The Member-Secretary
Chennai Metropolitan Develop-
ment Authority
1, Gandhi Irwin Road
Egmore, Chennai 600 008

Letter No. A1/15879/2005

Sub: CMDA - Planning Permission - Construction of ~~GF Residential~~
~~building at plot no: 1B, Eastwaram Nagar,~~
~~7th Street, Pammal Chennai-75, S.No: 105/3~~
~~Residential/Commercial Building~~
Block No: A of Pammal village

Development charges and other charges to be
remitted - Regarding.

Plan Showing the Proposed Construction of Dwelling in S.No.105/3, Block No.A, Plot No.1'B' at Eswaran Nagar, 7th Cross Street, at Pammal Village, Pammal Municipal Limit, Tambaram Taluk, Kancheepuram District.

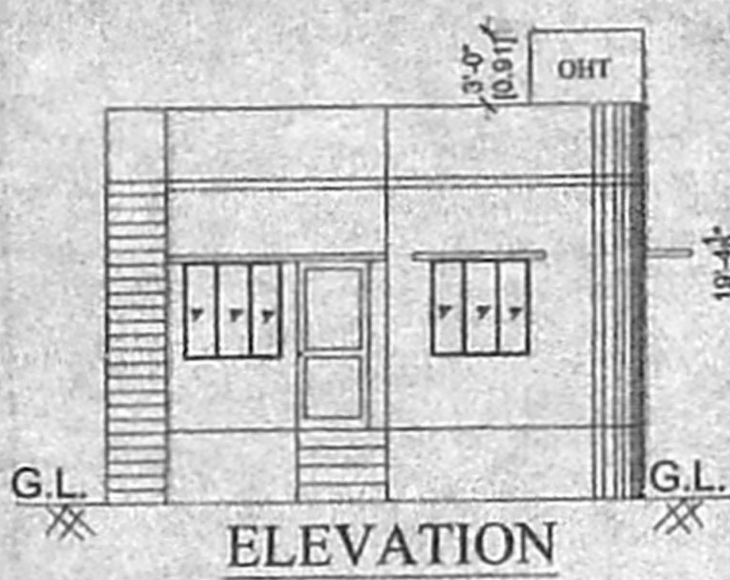
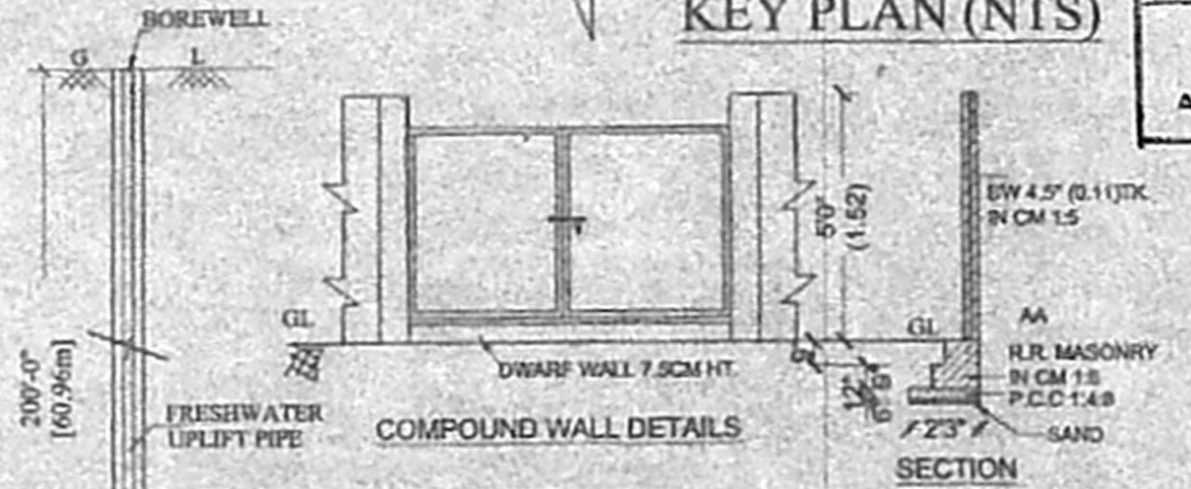
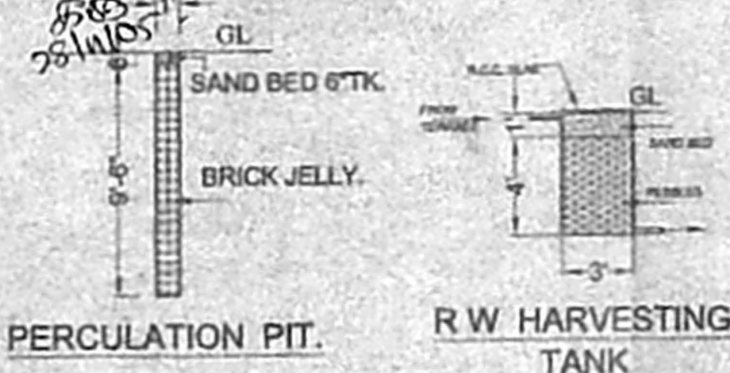
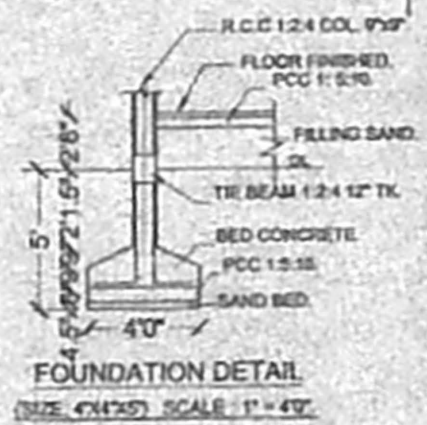
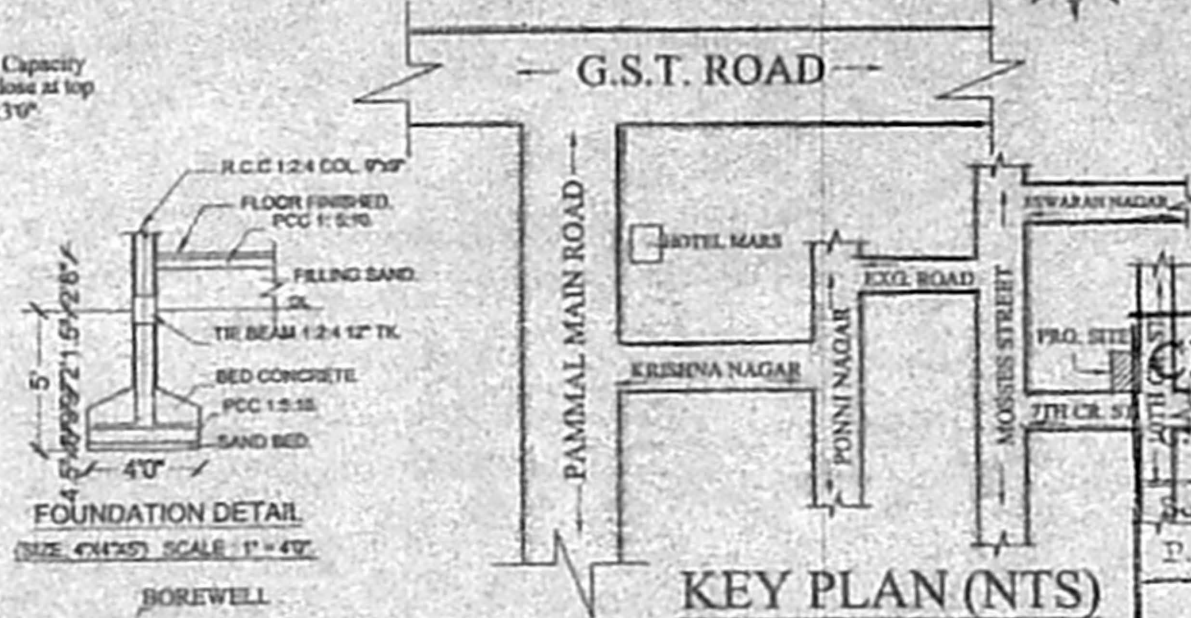
(i) Basement height to be 0.90m.

(ii) ^{Mentioning the} lengths and widths of the staircase and showing in the site plan and also distance from the site boundary ^{to be shown} ~~correctly~~.

(iii) Break up measurement for the building ^{to be shown} ~~correctly~~.

(iv) Compound wall details with section elevation and 7.5 cm dwarf wall along the gate including the location of the gate in the plan.

(v) RWH details as per the standard.
